## Appendix A- Record and Response to Submissions

Extracts from Government agency and authority submissions and submissions from the general public received in relation to SSD 17\_8351, and a response to each of these matters, has been outlined in the **Table below**.

21 June, 12:30 PM AEST

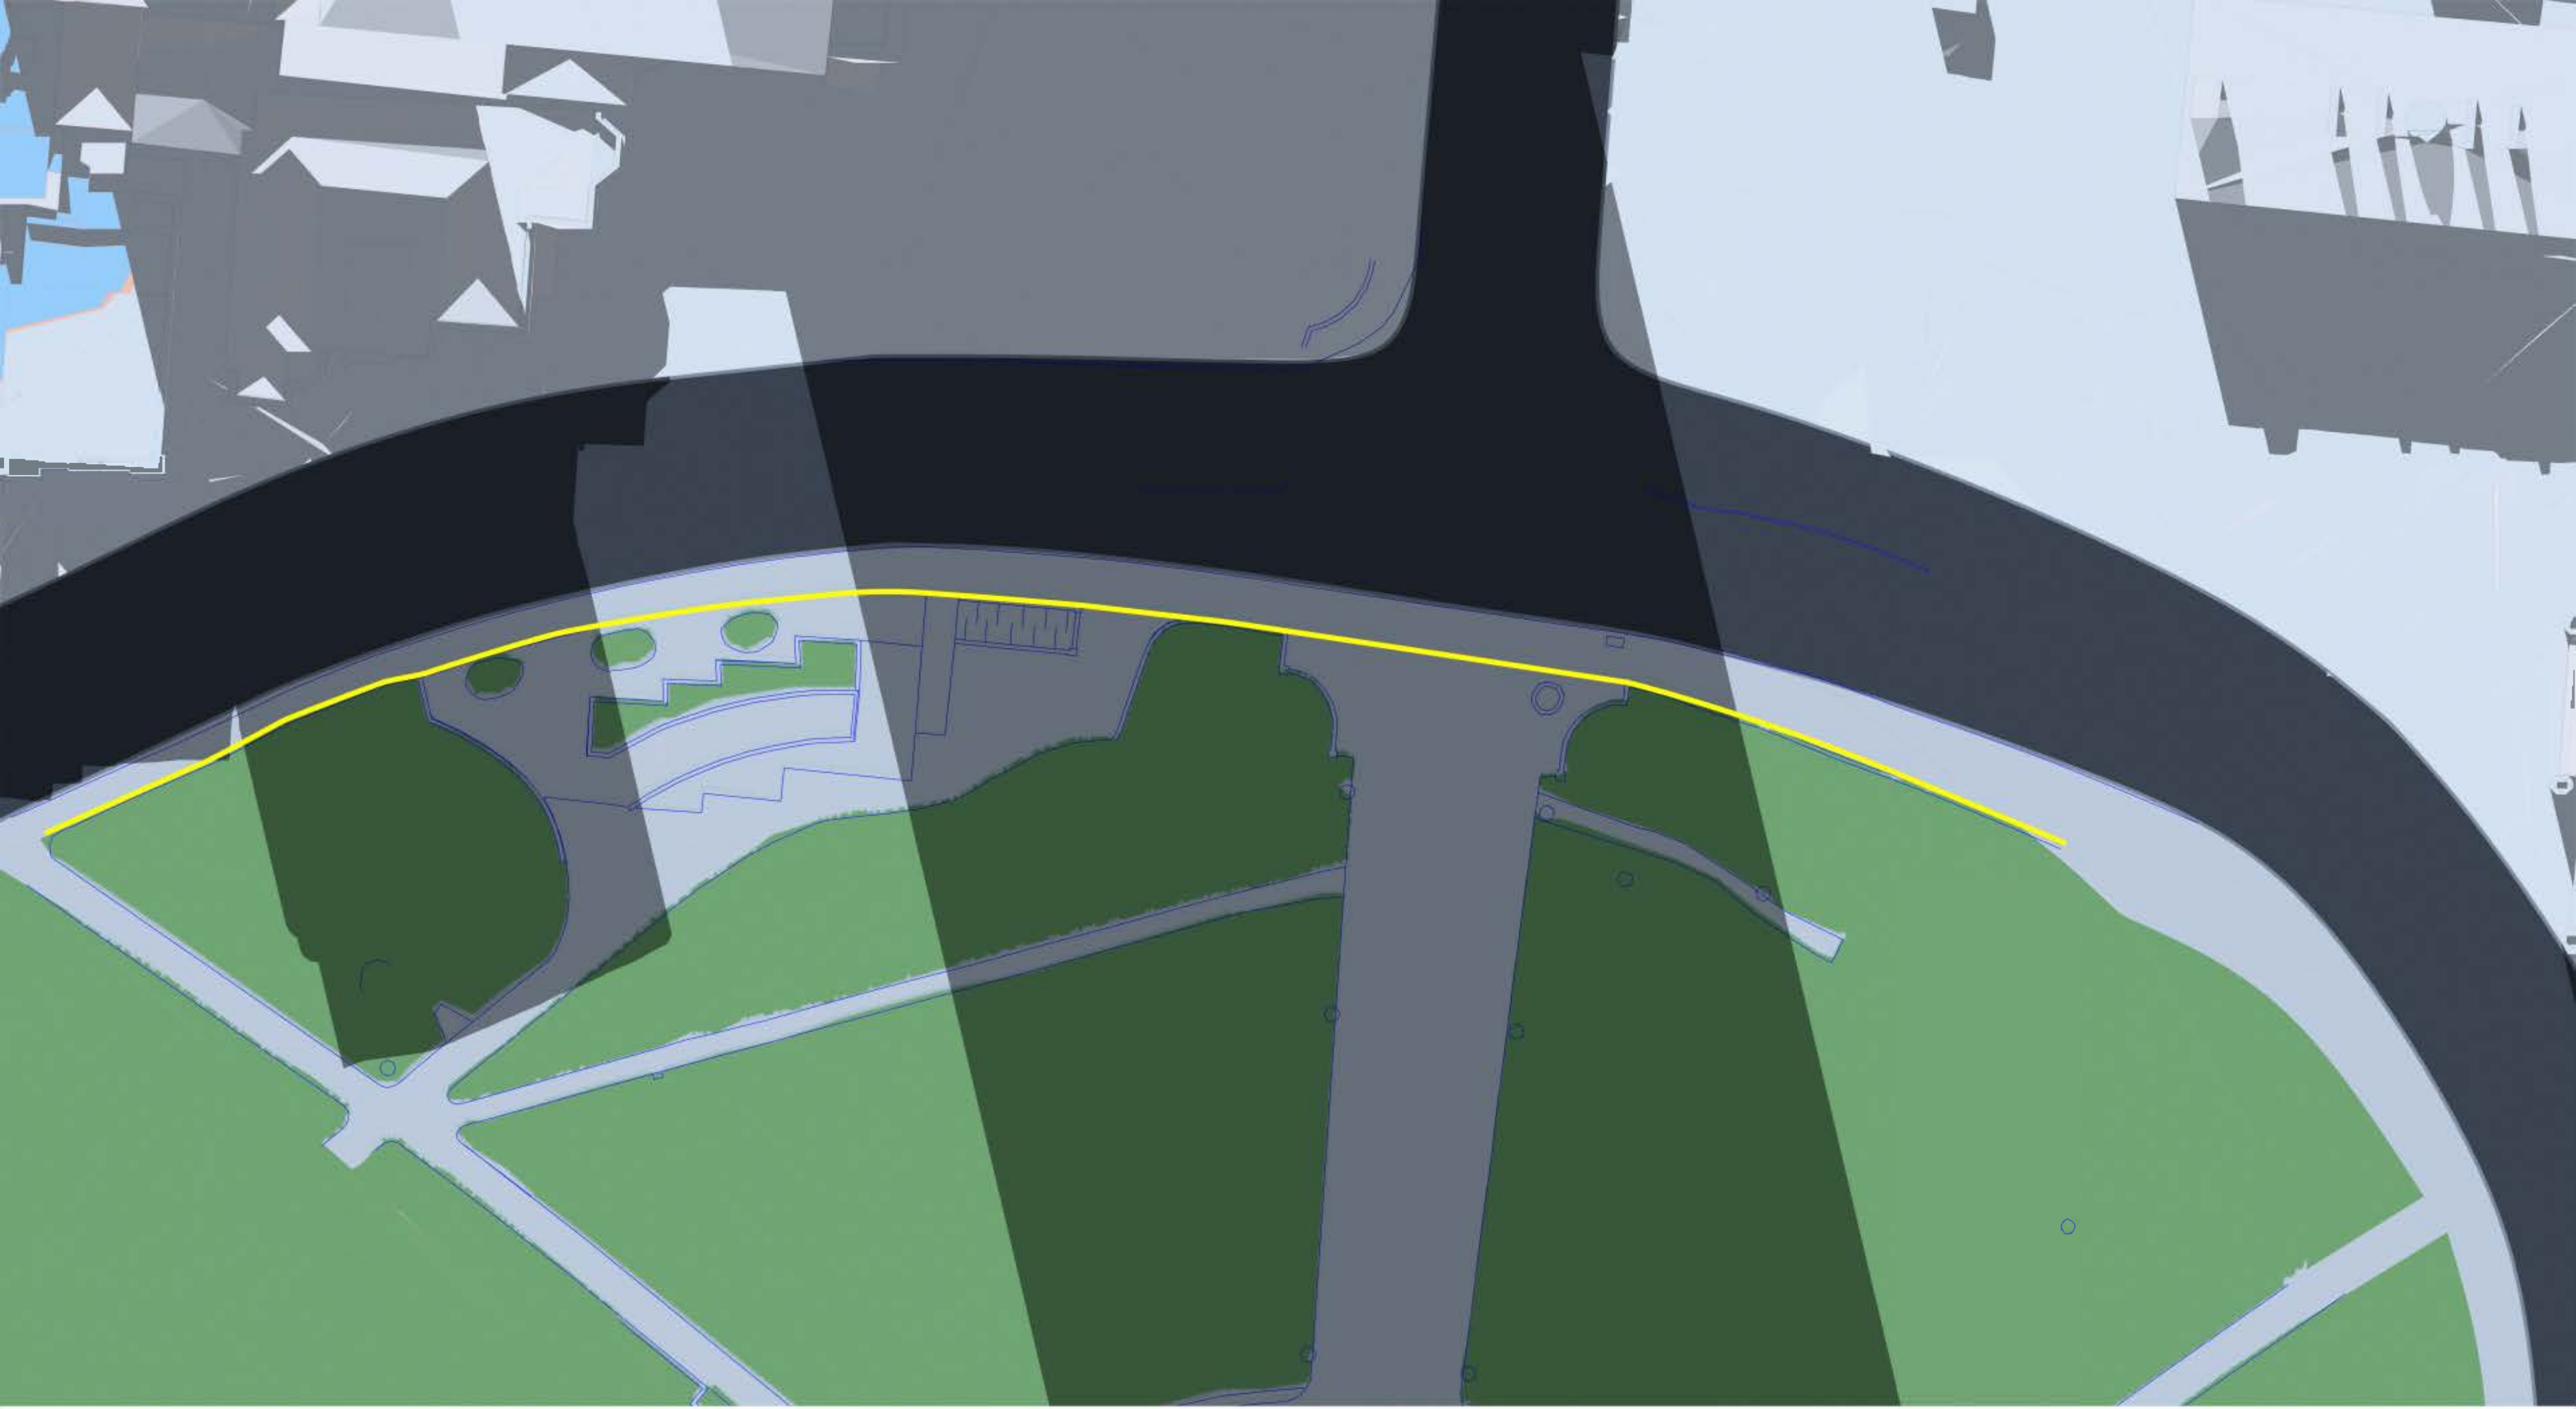
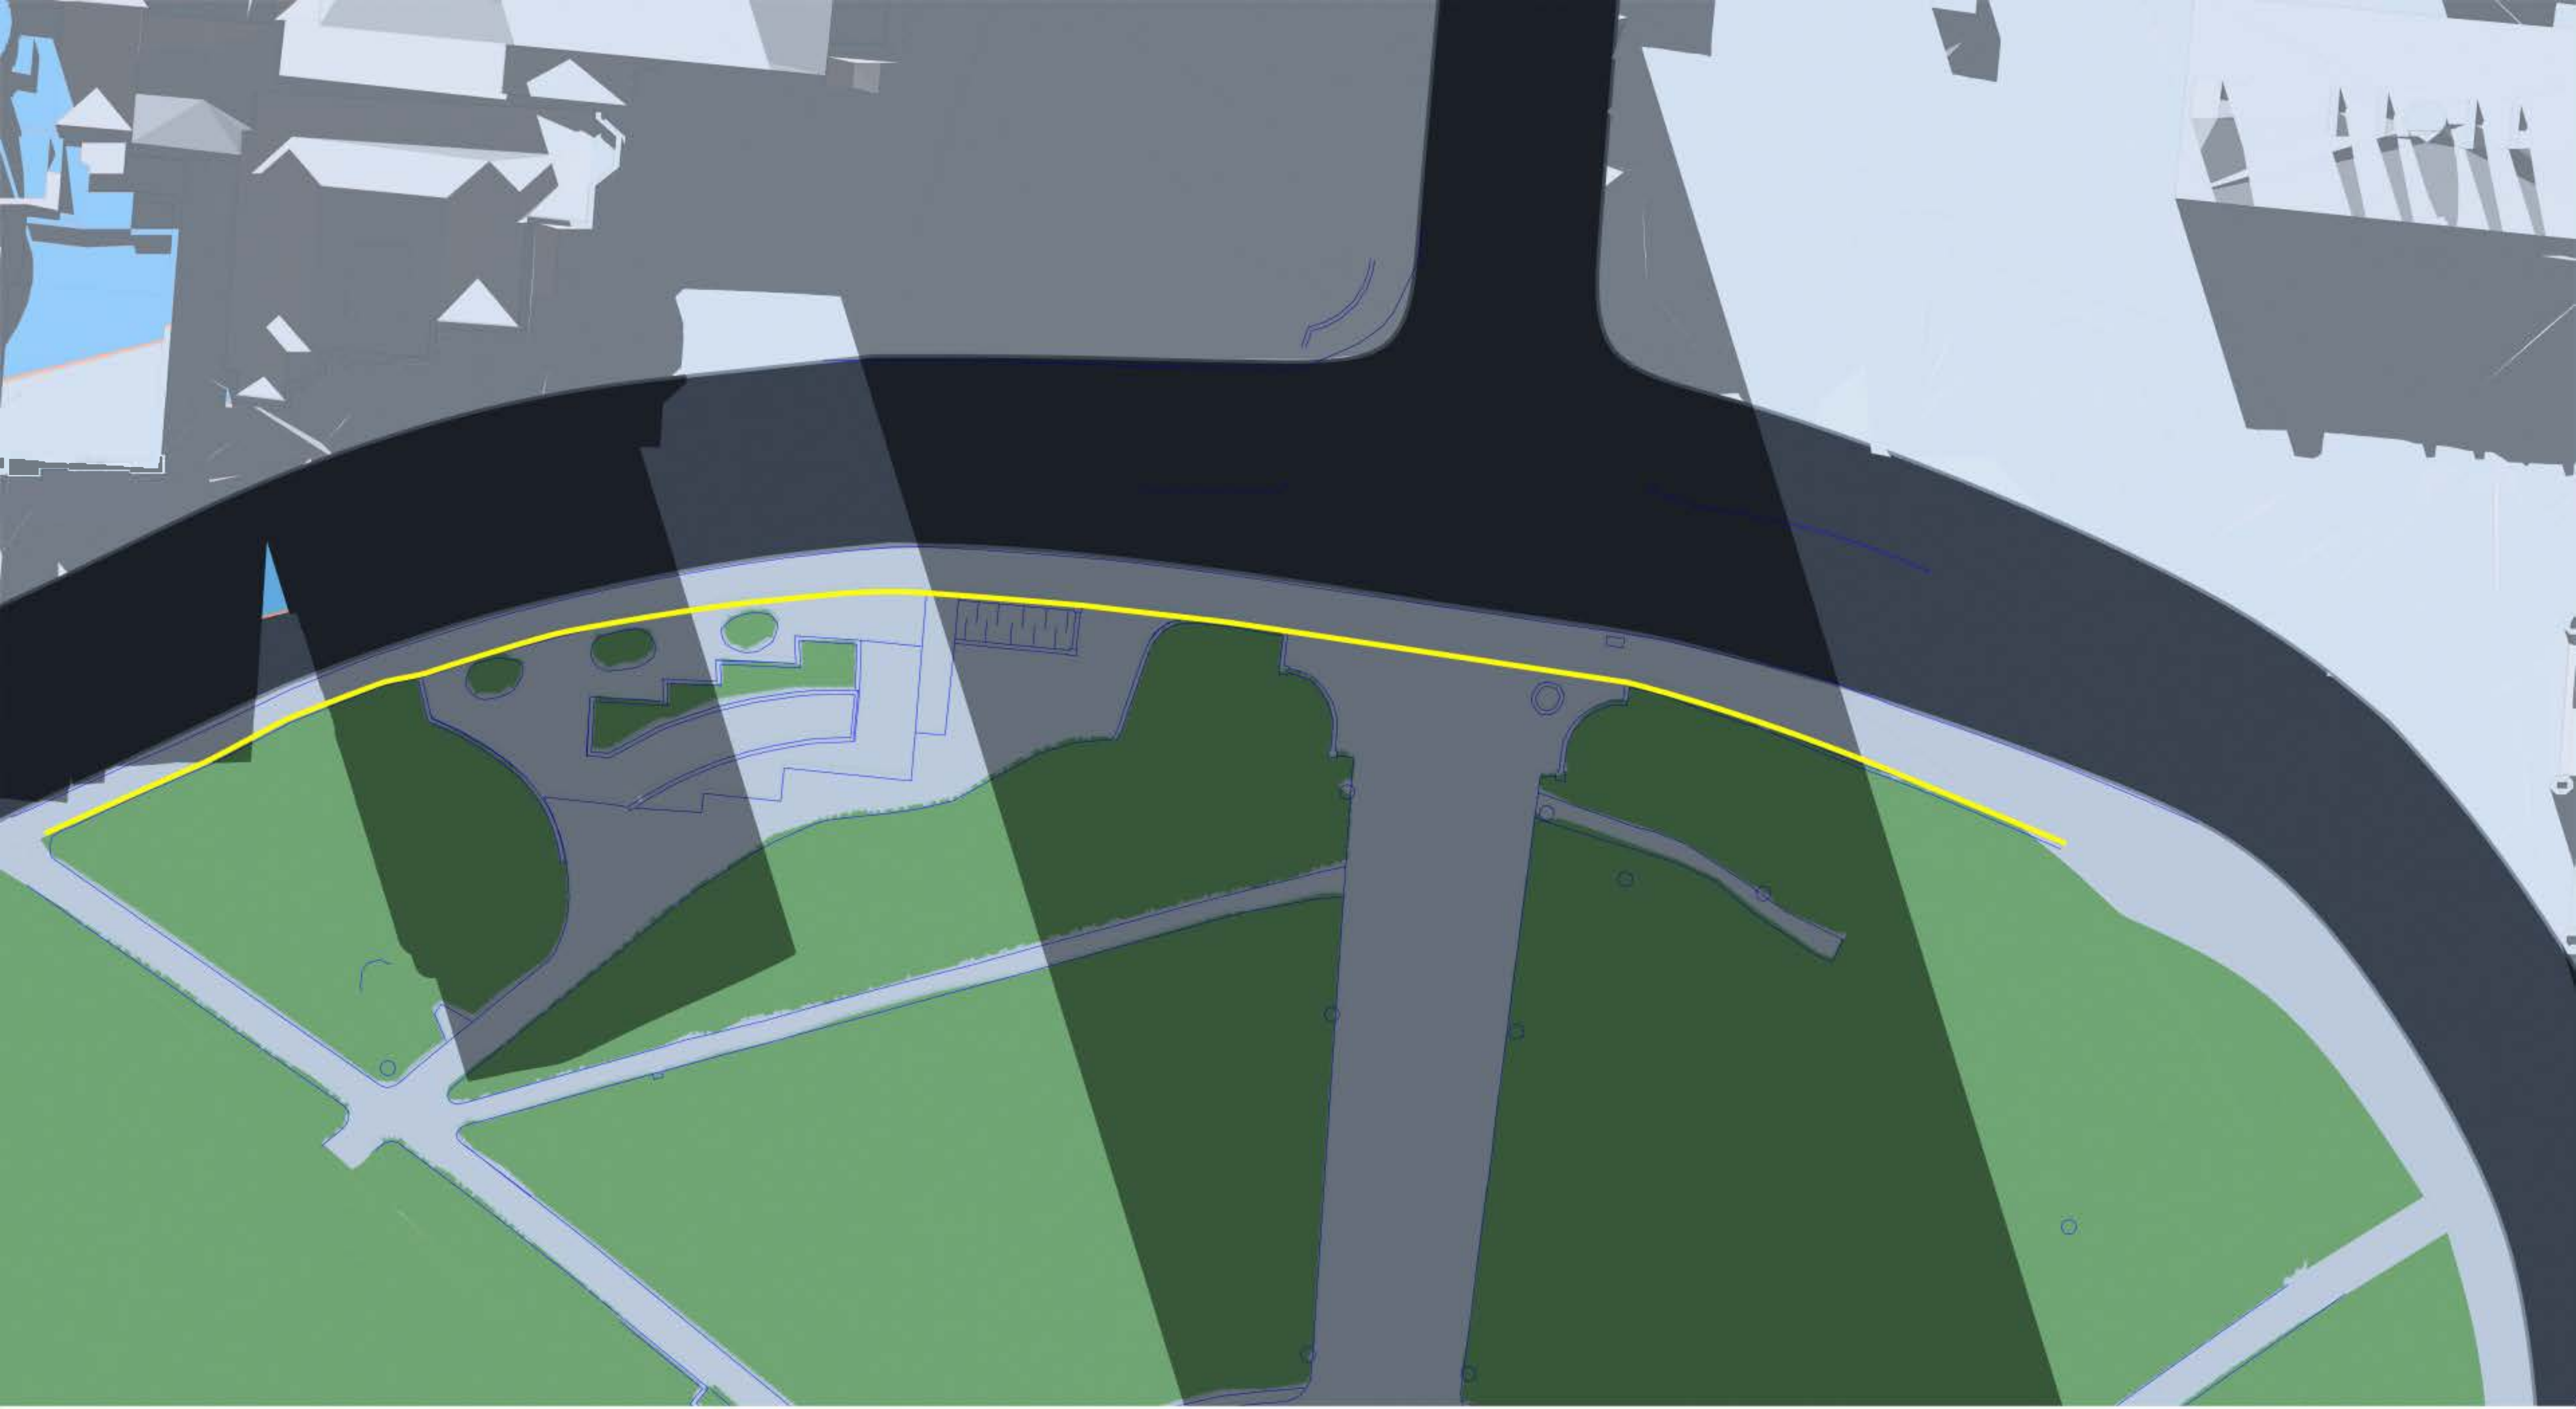
Review the impact of the proposal on solar access to Hyde Park in mid-winter, and how the proposal is consistent with the objectives within the SLEP 2012 to protect the amenity of public places. This should include an analysis of the overshadowing impacts on Hyde Park in comparison to a development which would apply the setbacks of SDCP 2012.	The revised overshadowing analysis at <b>Appendix C</b> confirms the relative impact of the proposed building envelopes when compared to a LEP/DCP compliant scheme. It demonstrates that in addition to the proposed envelopes being consistent with both the existing and potential future Sun Access Planes applying to the Site, these building envelopes will also not generate substantial or long-lasting shadows on Hyde Park consistent with the objectives and requirements of Cl. 6.16 of the Sydney LEP 2012. It is further demonstrated that minor overshadowing generated by the proposed envelopes is comparable to the compliant scheme, and as such are comparable to what would otherwise be expected under the controls as smaller, older buildings are replaced with new buildings designed to the City's height limits. The degree of additional shadow is also consistent with that which results from development in which the City of Sydney Council readily supports and approves (e.g. 148 King Street). Refer to the RTS for further discussion.
